Submission
October Amended Concept Proposal
Harbourside Shopping Centre Redevelopment SSD-7874

Submitter:	Marcel Joukhador
Relationship to development:	occupier of unit 703, 50 Murray Street Pymont

Image 48 Illustrative Scheme showing proposed relationship to Pymont Bridge

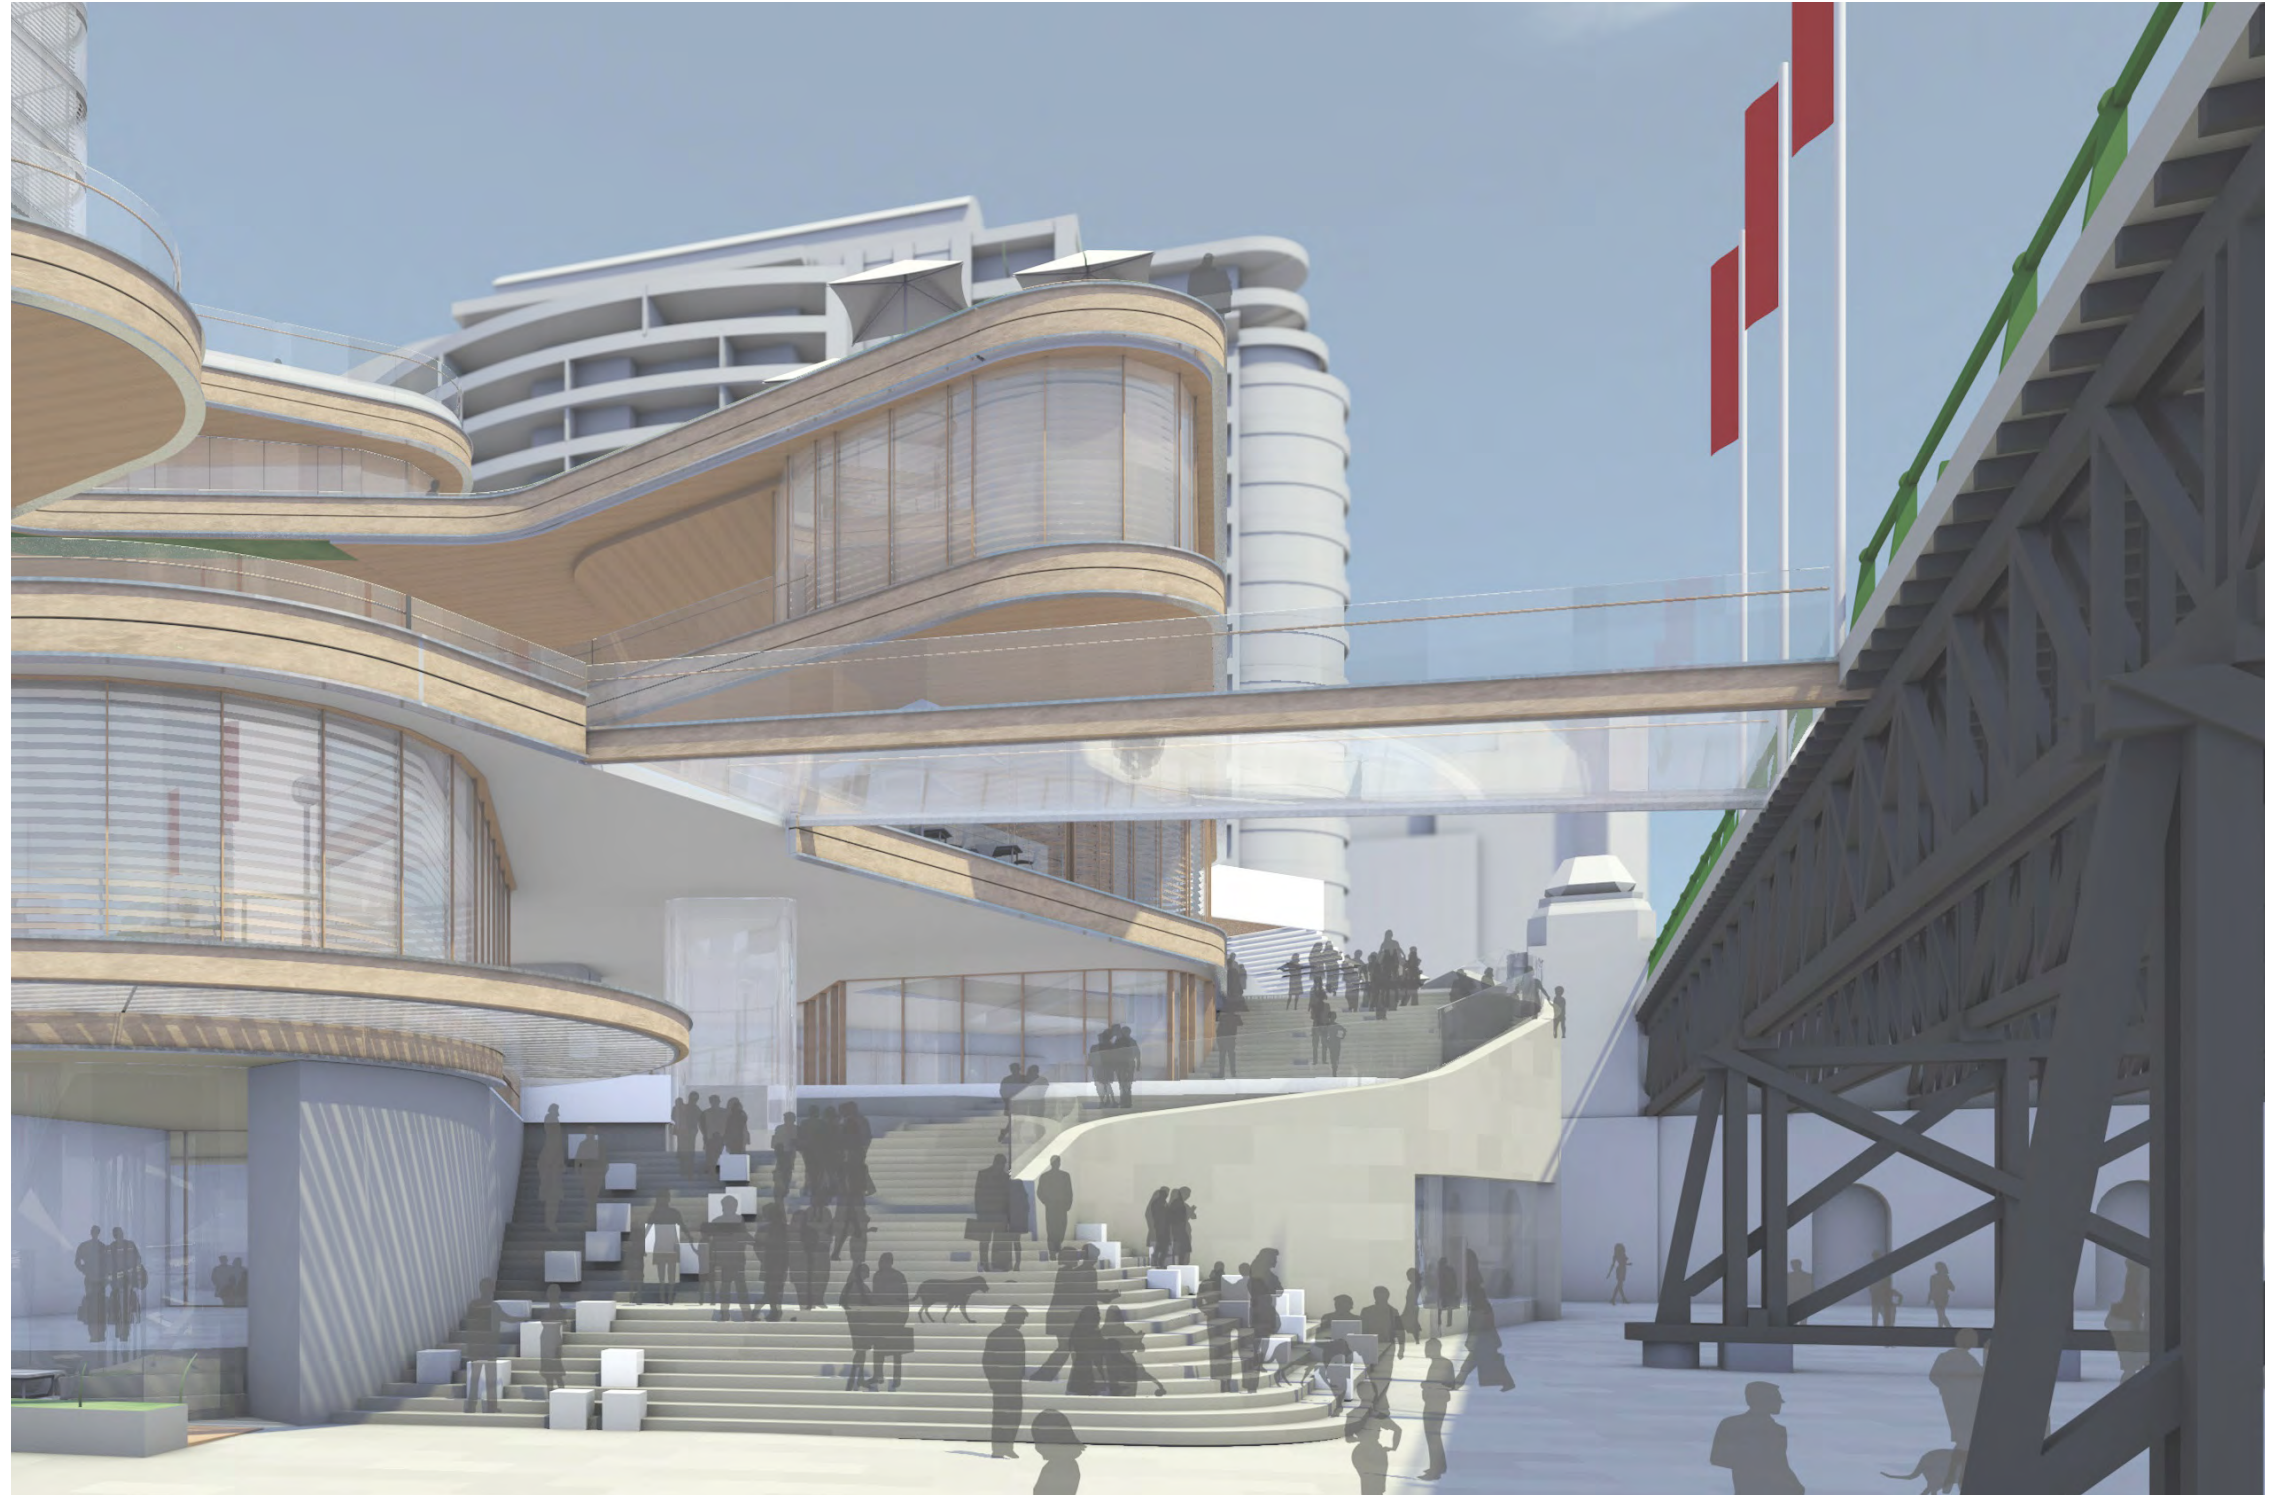
The podium setback to Pymont Bridge is only some 25 meters where the RL rises from 13.75 to RL 25 which still significantly overpowers the State listed Pymont Bridge. The Cockle Bay side of the Pymont Bridge has an RL of 12 for 65 meters.

The norther podium needs to be further reduced. The RL 25 element of the podium is of most concern and reducing this to the RL of the second tier of RL 17.6 setback for at least 75m from Pymont Bridge would be a minimum to achieve the objectives set out above.

Figure 4.4.5 Section through site and 50 Murray St (facing north)

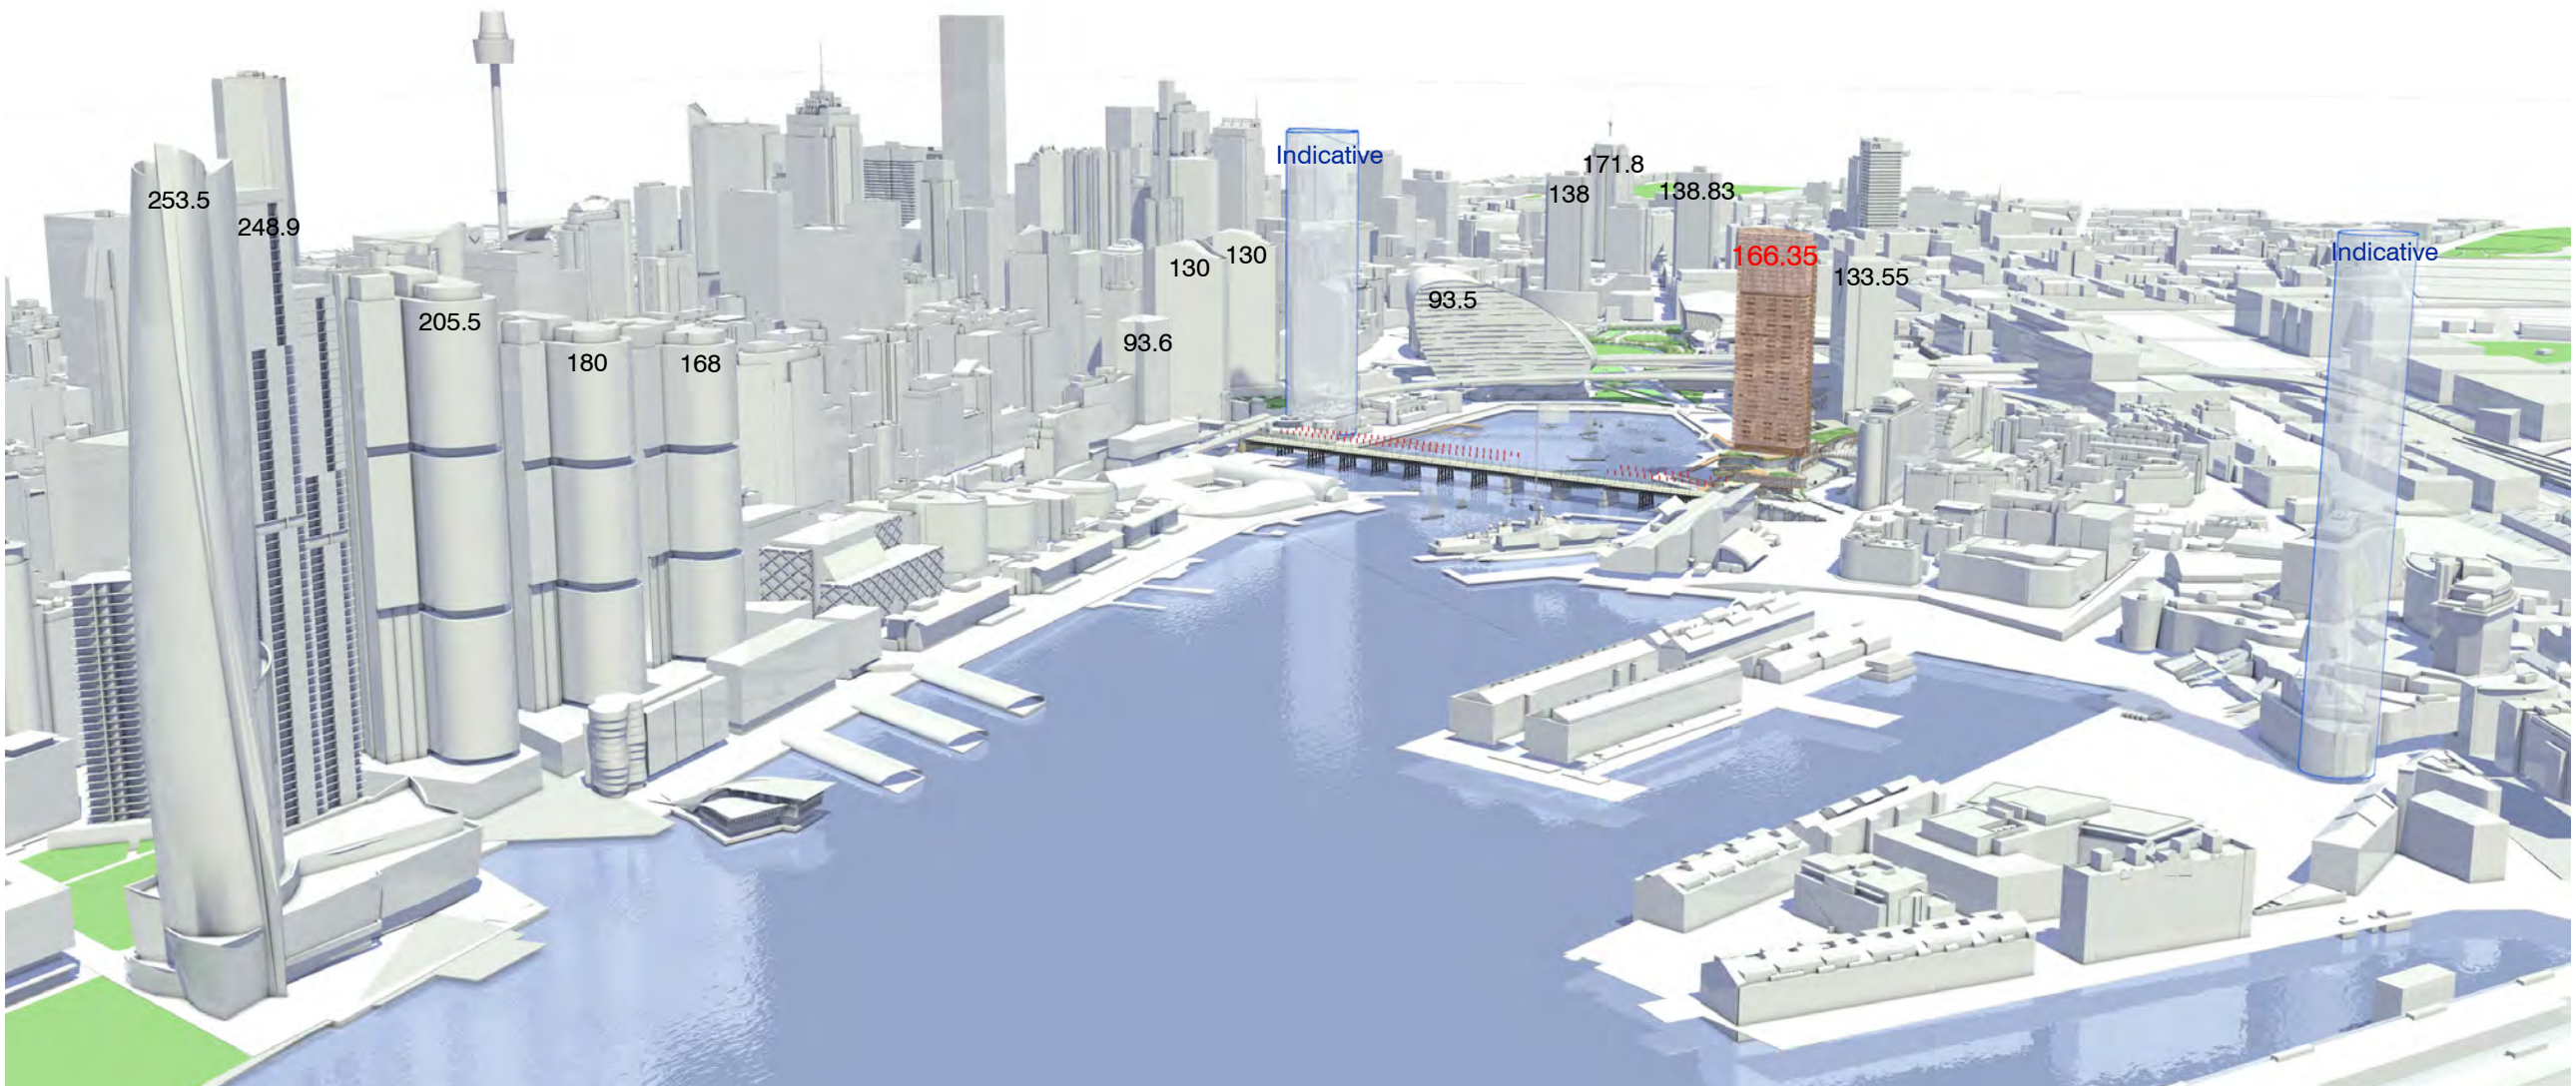
My views are east to Cockle Bay. These views are currently water views and are valuable to me. The amended concept still totally obstructs all water views of Cockle Bay from all areas of my apartment 703. The amended concept provides for a corridor view platform to the north which in no way reduces my easterly views of Cockle Bay. Further the building is curved and I live on the southern side of the curve and providing a corridor platform at the northern extreme provides no functionality at all.
